## Tracy Bellamy - SUBMISSION Epping to Thornleigh Third Track Environmental Impact Statement

**From:** Louise Rhodes <louise.rhodes@gmail.com>  
**To:** <plan\_comment@planning.nsw.gov.au>  
**Date:** 3/11/2012 12:36 PM  
**Subject:** SUBMISSION Epping to Thornleigh Third Track Environmental Impact Statement  
**CC:** <rail@2119.org.au>

Figure S.6 Cross-section and elevation - New Cheltenham Station concourse building (see also S.5 for artist's impression)

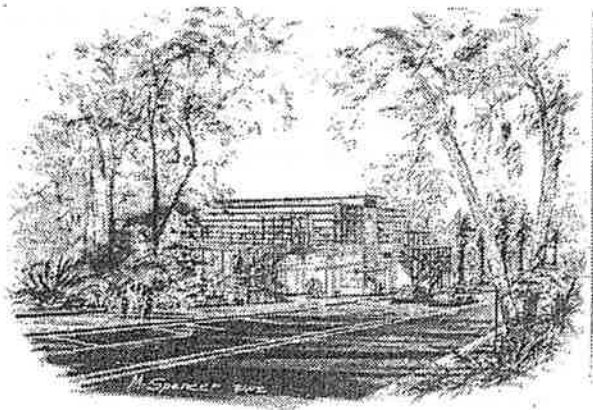
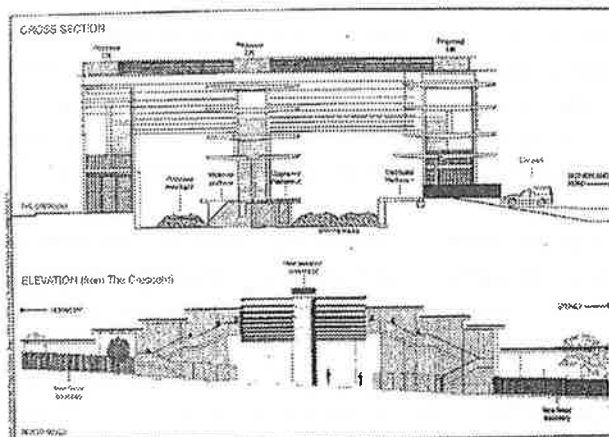
- The placement of the third line on the western side of the **Cheltenham Station** platform will require a free standing overhead bridge with lifts to the platforms. This is unacceptable because of:

- The visual impact of the proposed overhead bridge with lifts to the platforms.
  - The need for stairs and or ramps in case of lift breakdown and to meet statutory disability requirements

Figure 5.3 Future Cheltenham Station layout

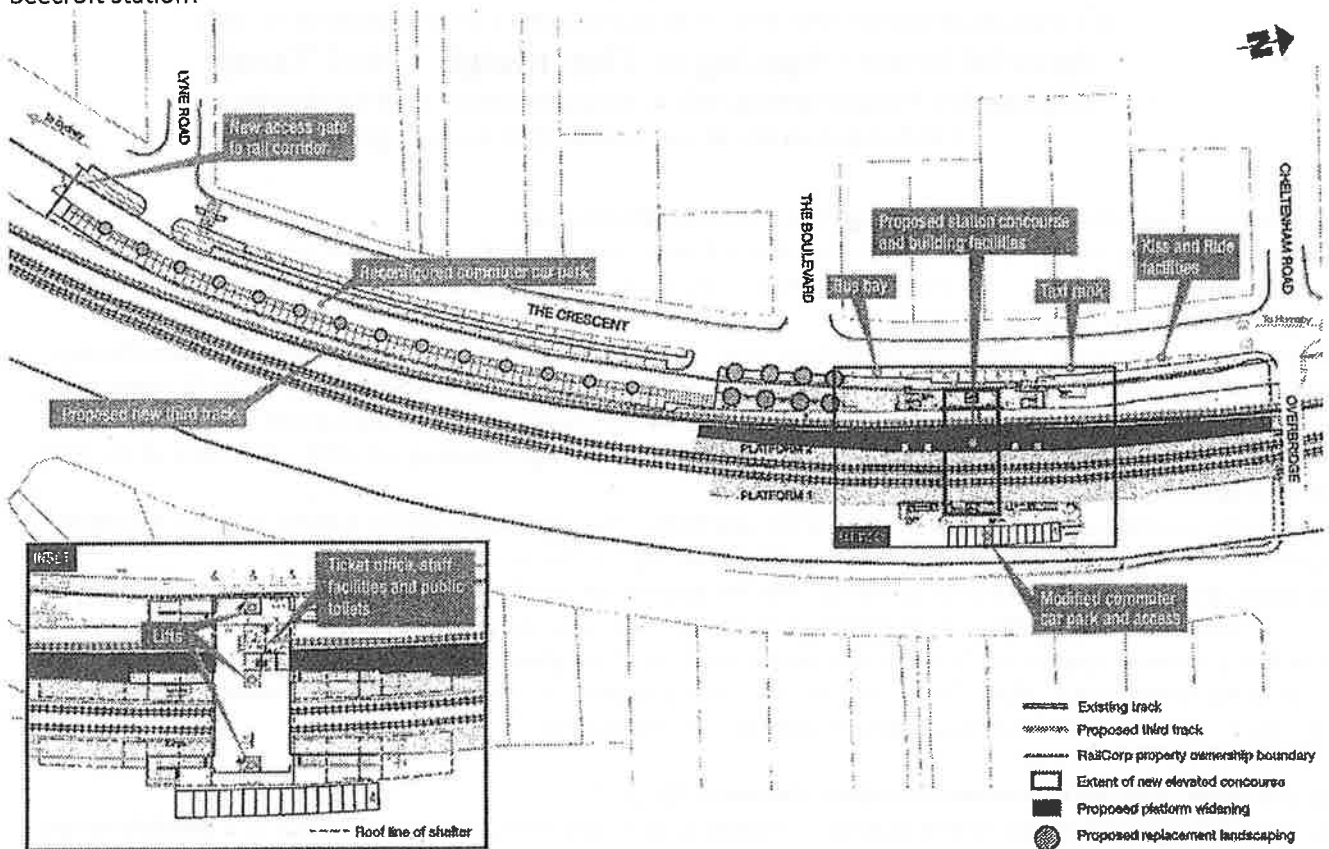
- the lengthening of the car park on the western side to Lyne Road goes through an area subject to flooding.
- There is no plan to upgrade Beecroft Station. Beecroft will be impacted by:
